From: [Dr Malcolm Hockaday FRTPI](#)
To: [silvertowntunnel](#)
Cc: [Marcello Burbante \(MarcelloBurbante@uandiplc.com\)](#); [Vicky Fowler \(Vicky.Fowler@gowlingwlg.com\)](#); [Matt Pochin-Hawkes](#); [Gavin Watters \(GavinWatters@uandiplc.com\)](#)
Subject: SILVERTOWN TUNNEL - Further representations on behalf of U+I Group PLC [NLP-DMS.FID150477]
Date: 20 March 2017 12:54:05
Attachments: [image001.png](#)
[image002.png](#)
[Letter to RB Greenwich .pdf](#)
[Silvertown Deadline 4 response Mar 17.pdf](#)

The following key points are offered as the interim response, focussing on Appendix C C.6.2 Tunnel Ave:

**PLAN**  
SCALE 1:250 @ A1

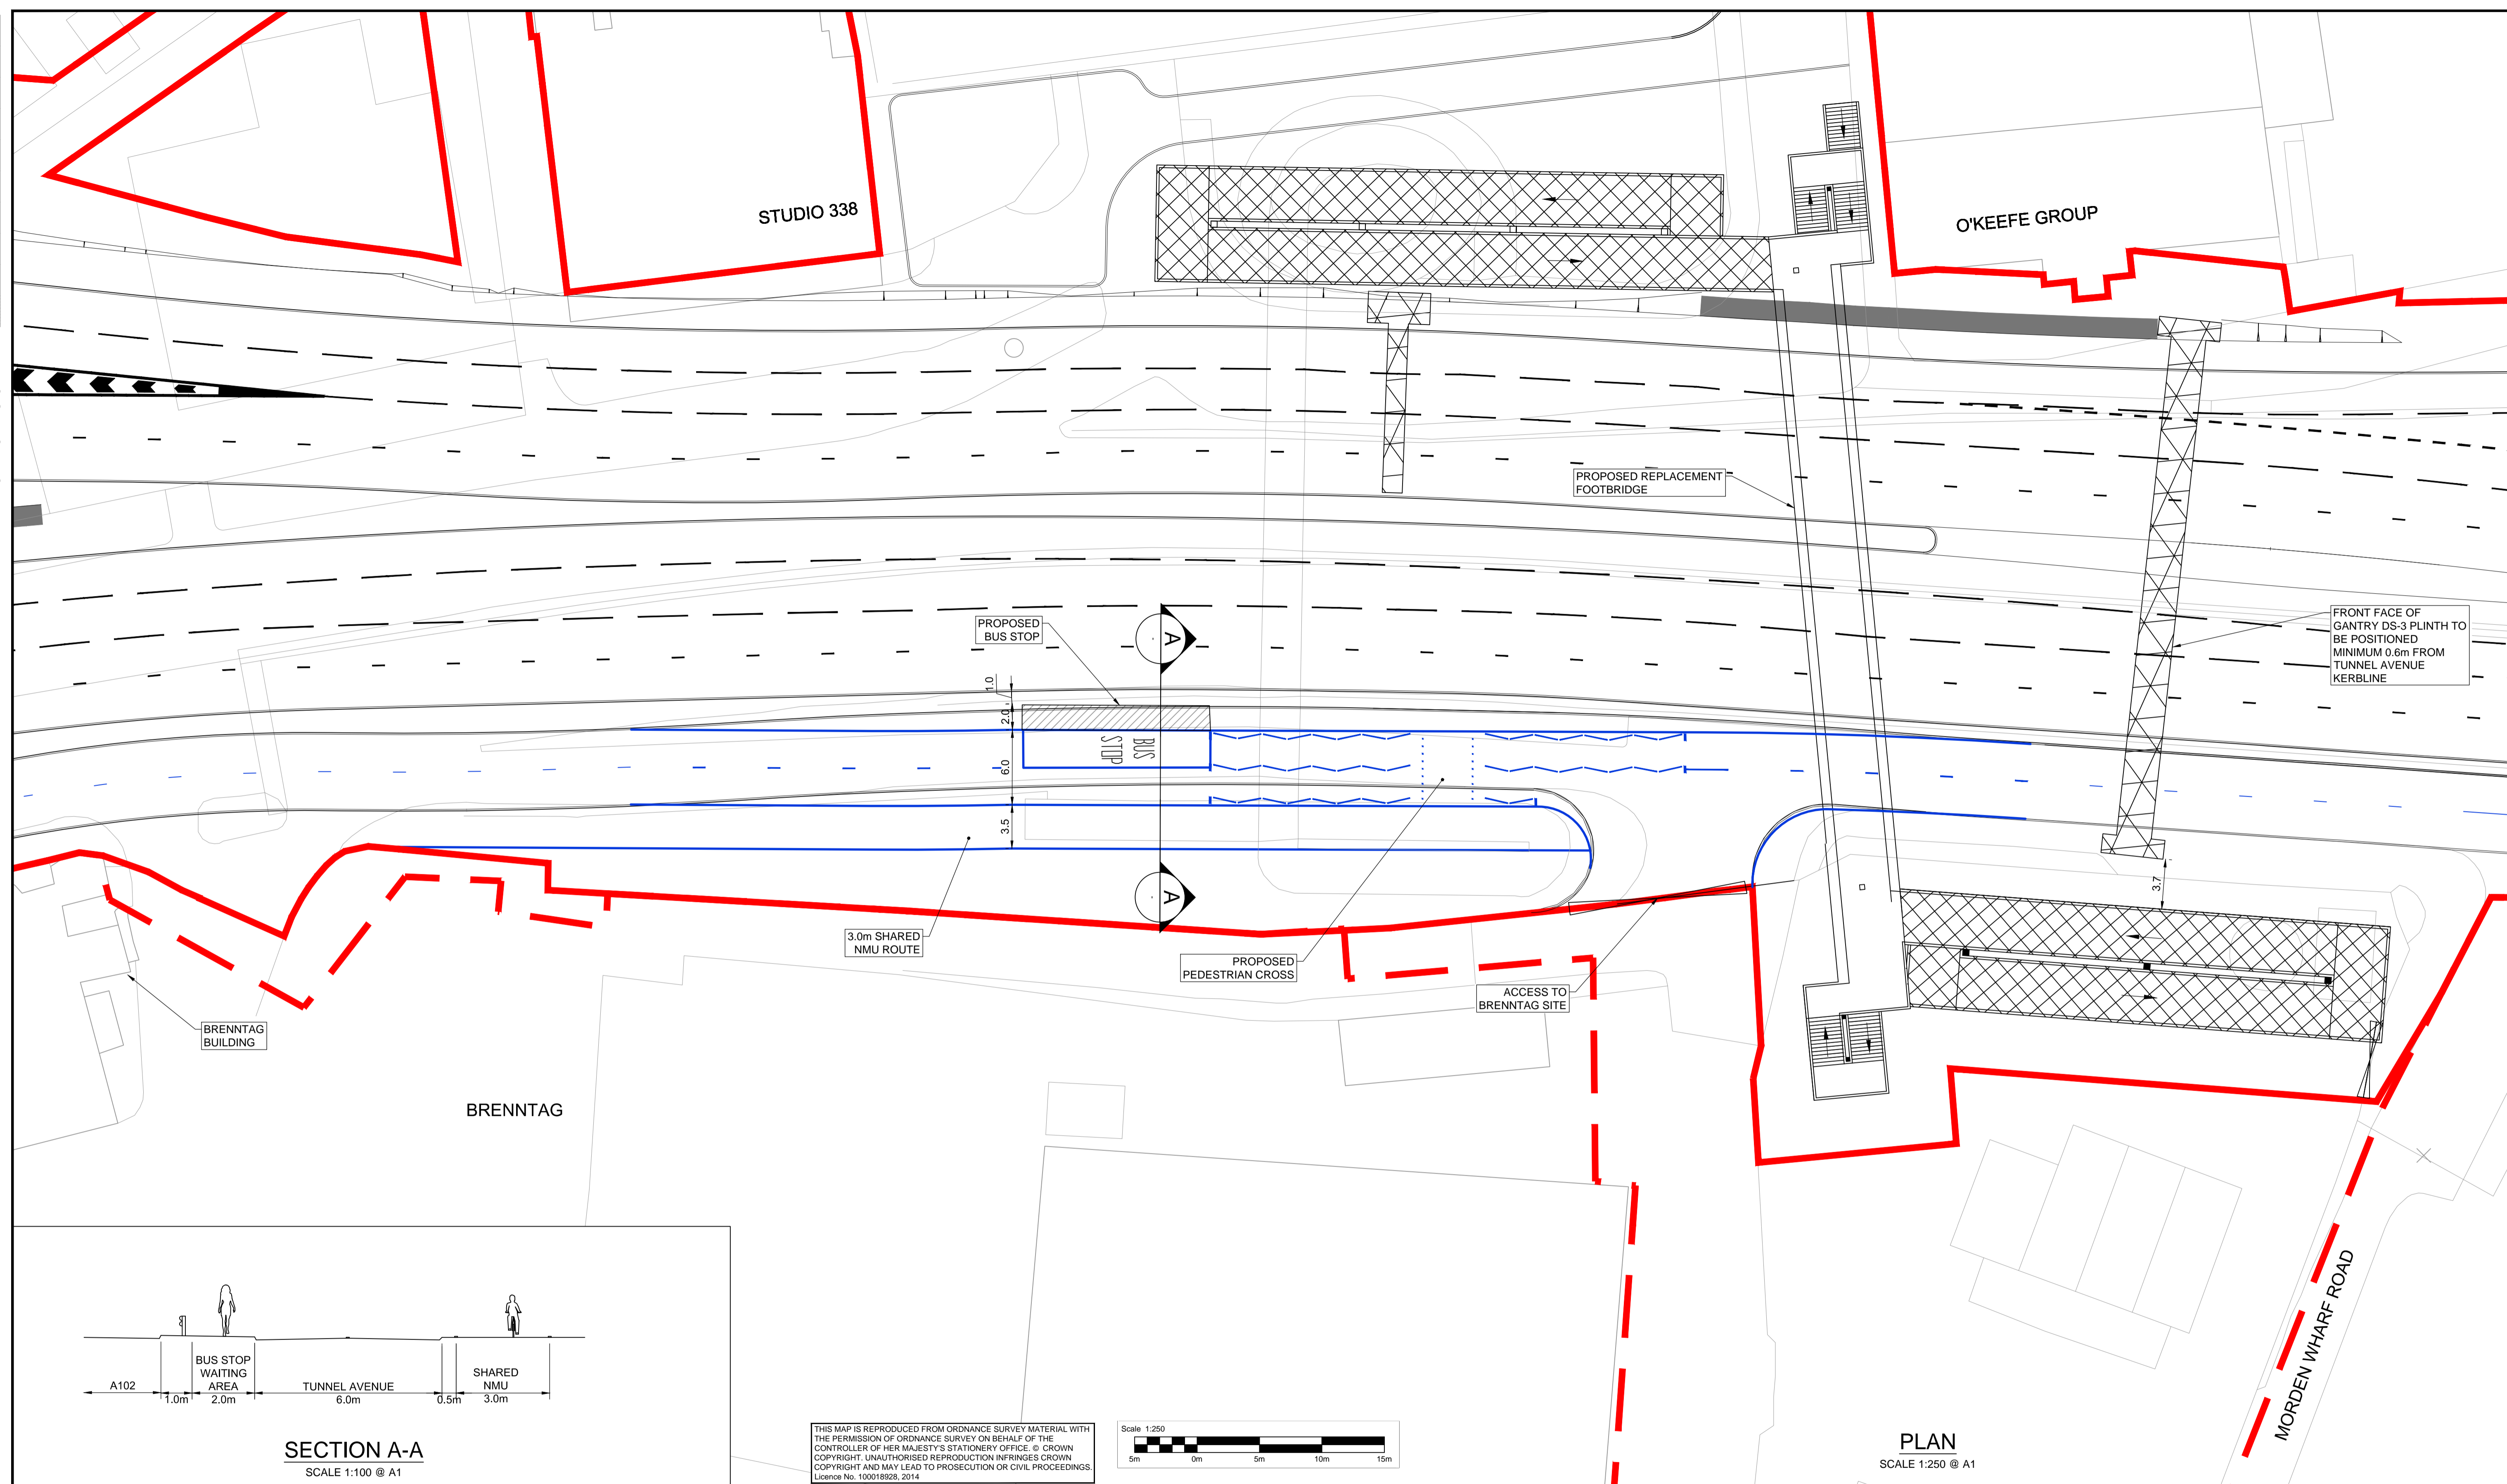
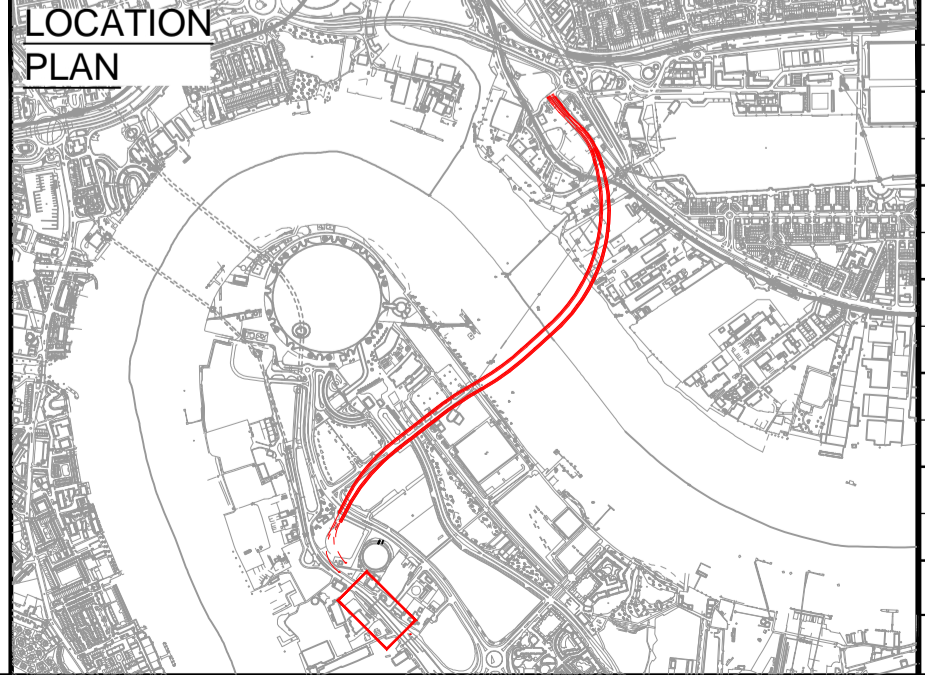
1. It appears that TfL is still not intending to offer bus stop creation on Tunnel Avenue
2. It nevertheless believes that a southbound stop can be accommodated by changing the alignment of Tunnel Avenue through a minor diversion or chicane into the 'Brenntag bulge' of footway where the existing footbridge ramp sits, allowing establishment of sufficient length of pedestrian refuge for bus users on the southbound side of Tunnel Avenue
3. It intends to provide only for a 3m wide shared surface footway/cycle path on the western side of Tunnel Avenue as far as the southern extremity of the scheme's land take, with a pinch point at the Brenntag office building which it indicated RBG and TfL are both content to live with (rather than knock down an office building) – but still only to a 3m wide shared surface standard elsewhere rather than the desirable 4.5m width.

- We therefore remain cautious that TfL can actually deliver these elements as part of the Silvertown Tunnel, until we see an updated plan of the scheme indicating

- a) the ability to provide the suggested chicane to create a short section of pavement to allow a southbound bus stop, with resultant lengthening of the proposed Boord Street overbridge and

- b) that such a solution is in accordance with normal TfL standards.

- a) adequate bridge length to accommodate safe southbound bus footway refuge
- b) adequate footpath/cycle widths around the ramps/stairs at each end,
